ACP ORAL HEARING (ONLINE)  
CPO UE ADARE RATIONALISATION SCHEME

EVIDENCE PRESENTED BY JOHN DORE  
FBA CONSULTANTS

MR. NED HOULIHAN (OBJECTOR)

18<sup>TH</sup> FEBRUARY 2026

Figure 4-2 Proposed Works

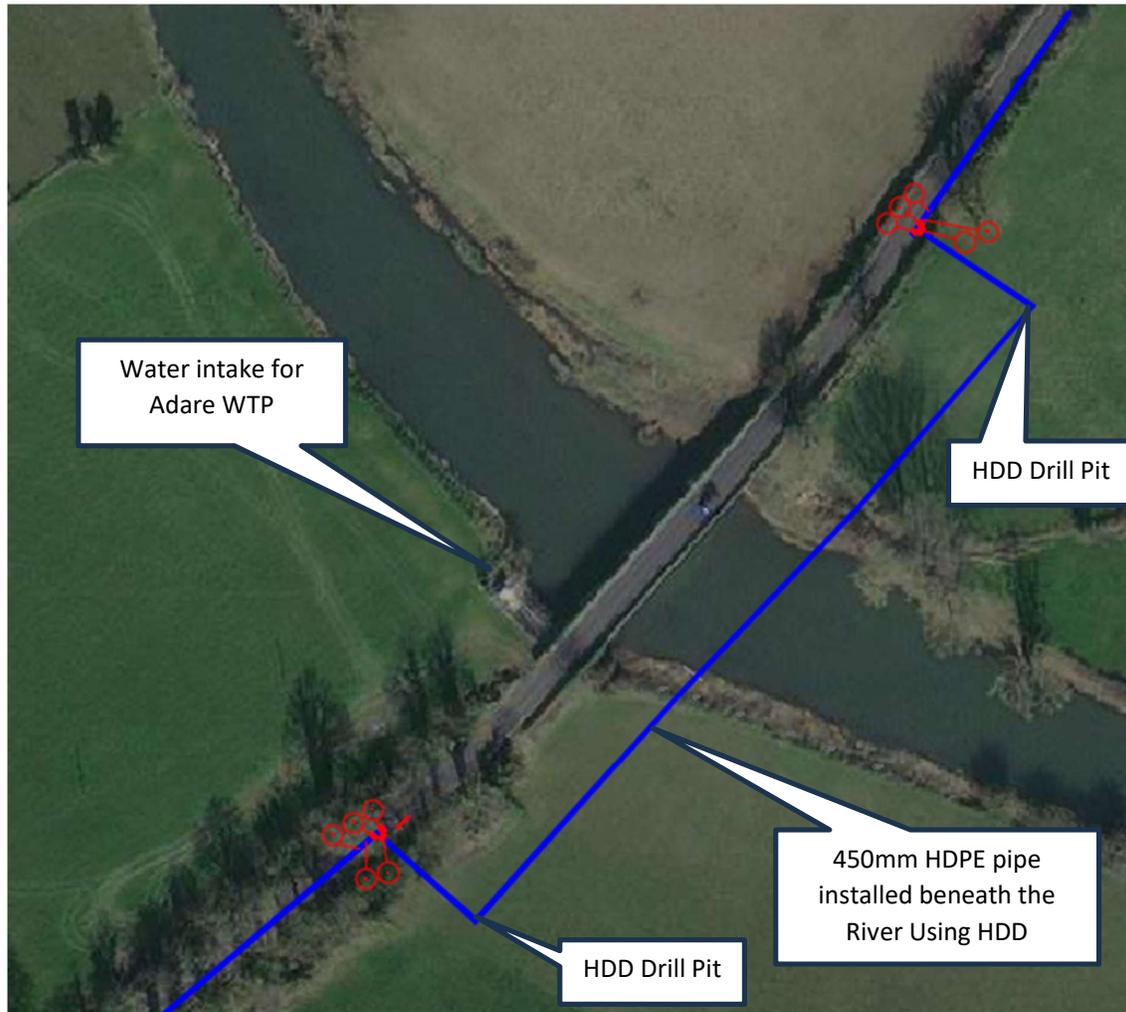
The drawing on the CPO planning report received does not match the works that have already been conducted

Pipe is on objectors side of the road in drawing – there are no road crossings visible?

Figure 2 – Drawing UE/10051295/CWL/0002

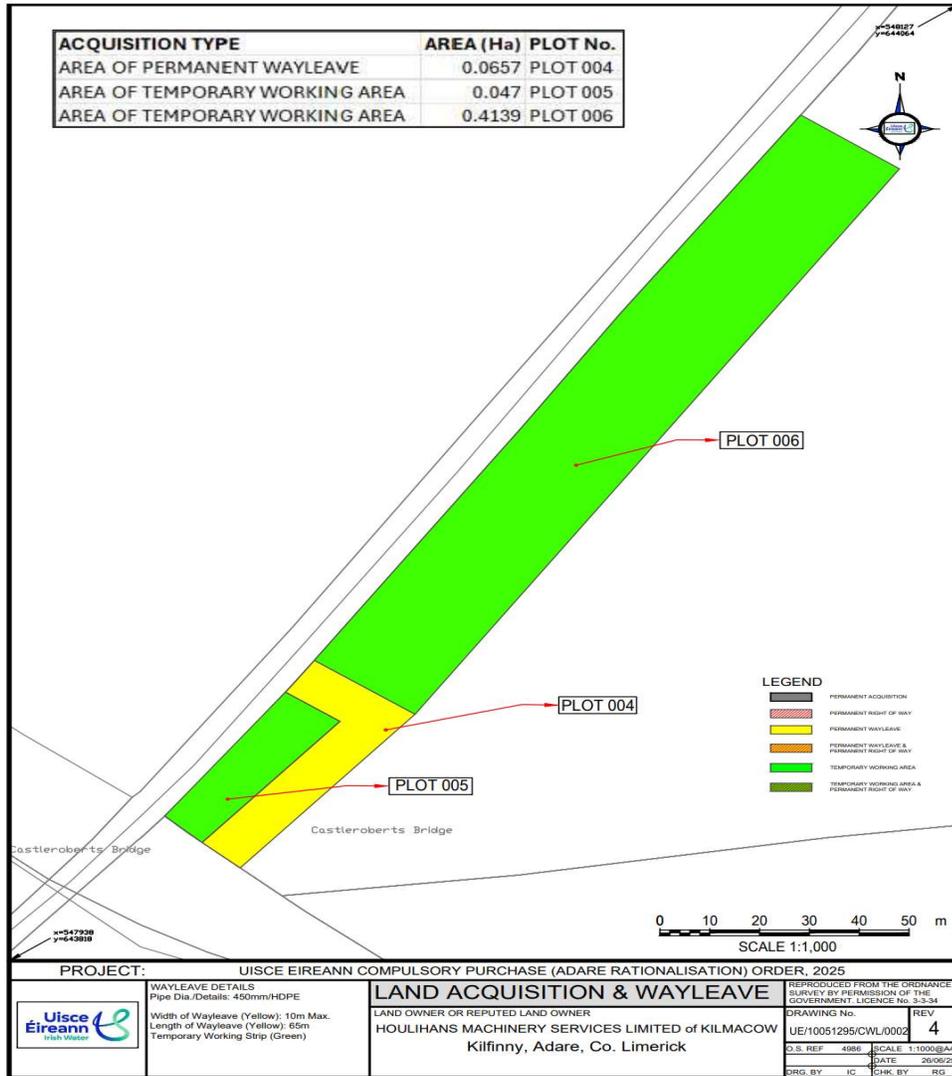
B. The length of the proposed route shown in Fig 1 of the Letter of Objection does not accurately reflect the temporary working area to accommodate the pipe string. The CPO drawing UE/10051295/CWL/0002 shows the extents of the route in question.

Figure 4-1 Objector's Proposed Route

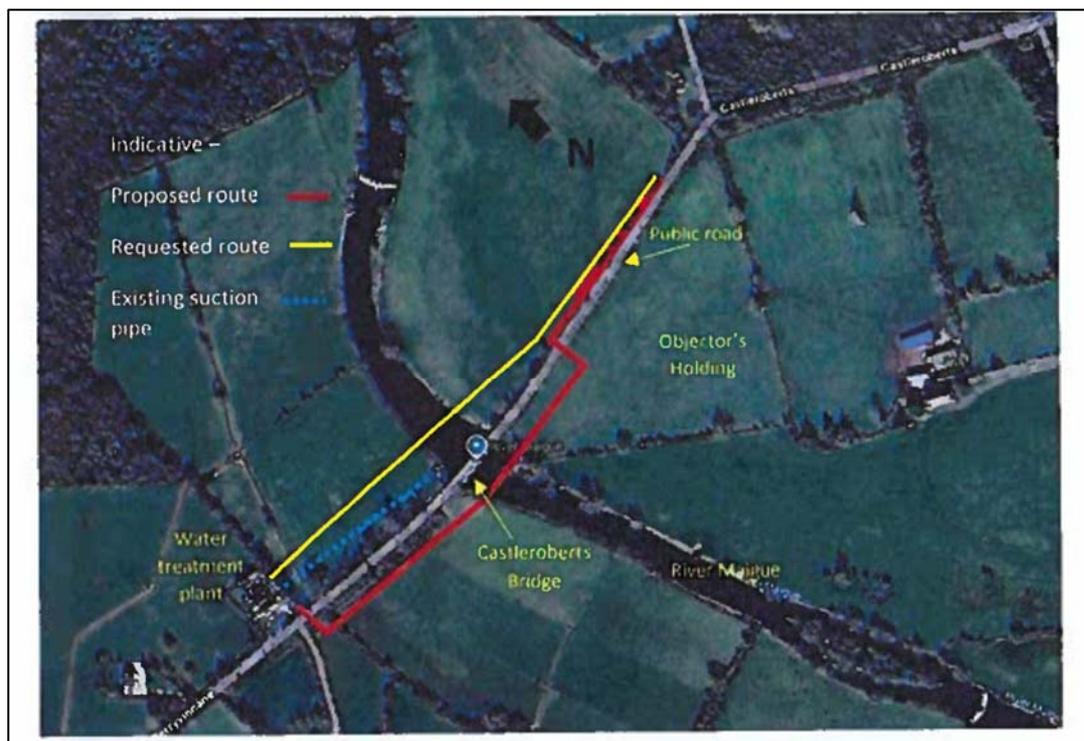
1. “The objector is opposed to the proposed route of the scheme and requests that it be relocated to the opposite side of the public road from his holding. This alignment would place the entire scheme on the same side as the existing treatment plant. The proposed route requires two road crossings and has at least three right angle joints which compromise pressure and are more prone to leaks. The proposed route has a greater cumulative impact on the three affected adjacent holdings at his location. The requested route therefore represents the more logical and appropriate route”.

A. The ‘proposed route’ as provided for in Fig 1 of the Letter of Objection does not reflect the proposed route of Uisce Éireann. The objector shows the route located in the land across the road from his land before crossing the road and entering his land. This is inaccurate. The designed route is within the public road and enters private land either side of the river crossing.
